Re: **Winsome Filing No. 3 PCM Certification Letter**  
**El Paso County, Colorado**

WINSOME FILING NO. 3  
EL PASO COUNTY, COLORADO  
CONSTRUCTION DOCUMENTS  
POND 1 OVERVIEW

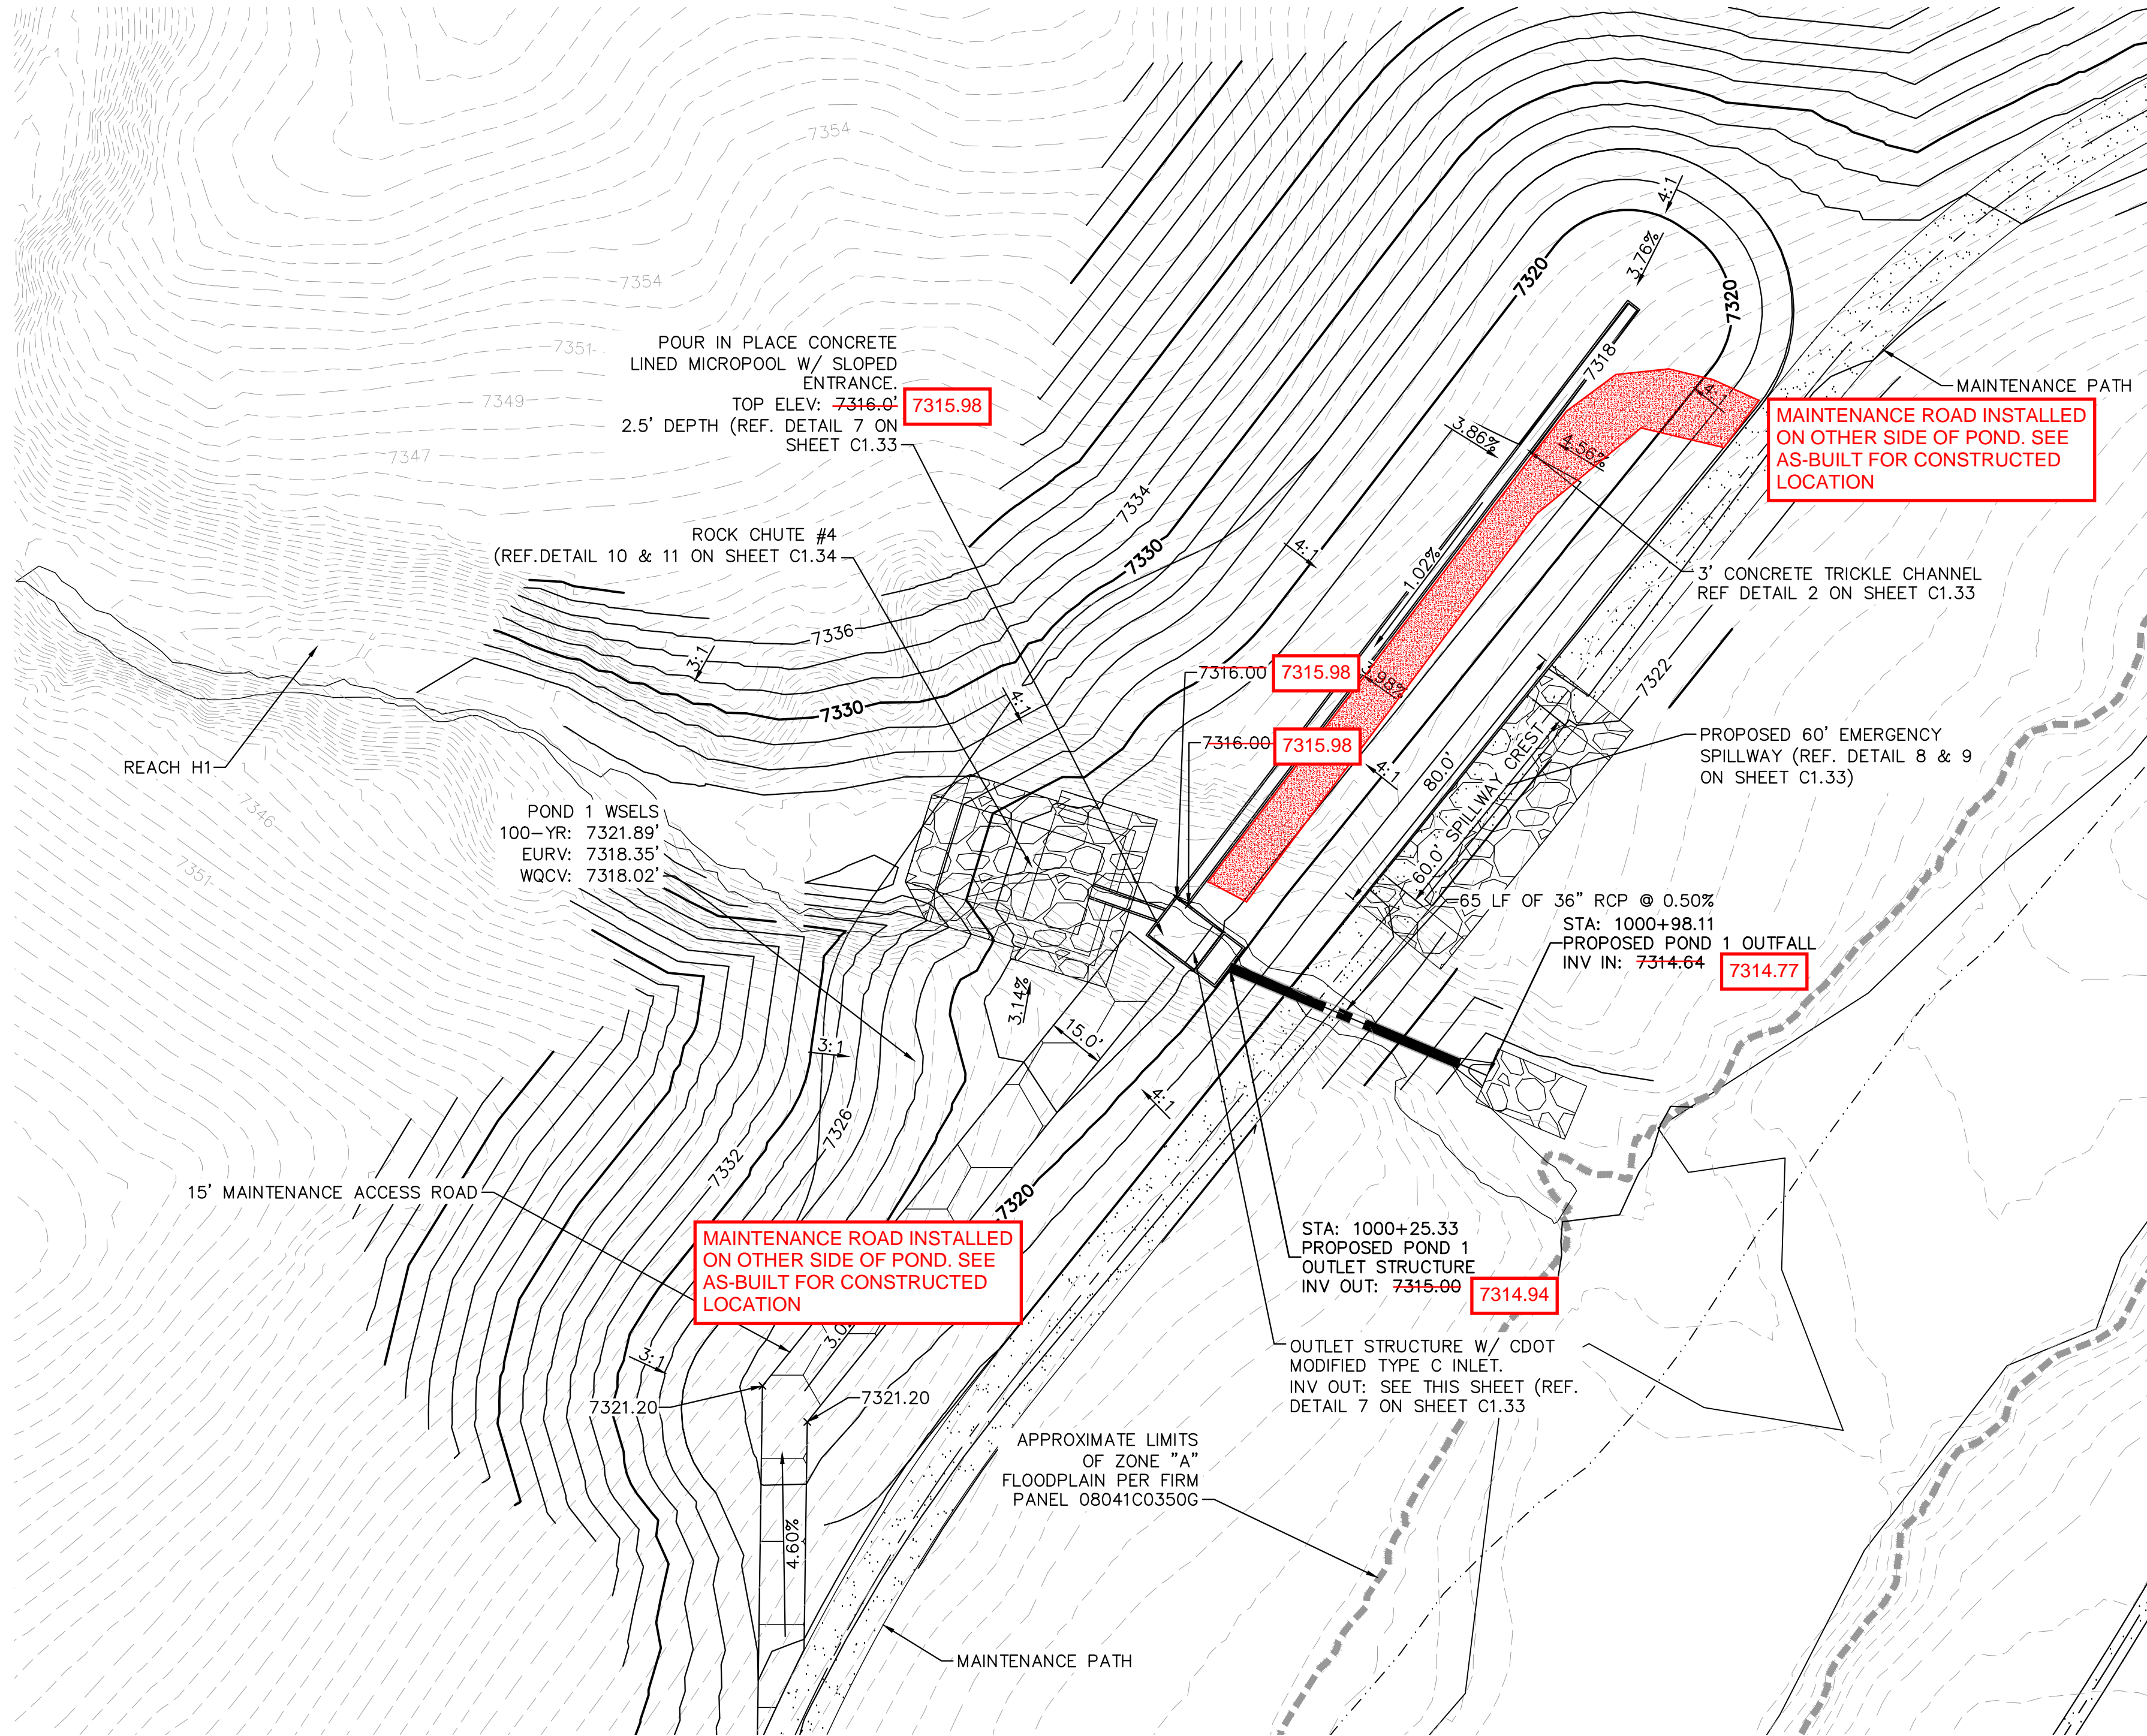
Add clarification that there are both ponds (A, 1, 2, 3) and runoff reduction providing WQCV treatment on site. Runoff reduction must be certified as well and include calcs
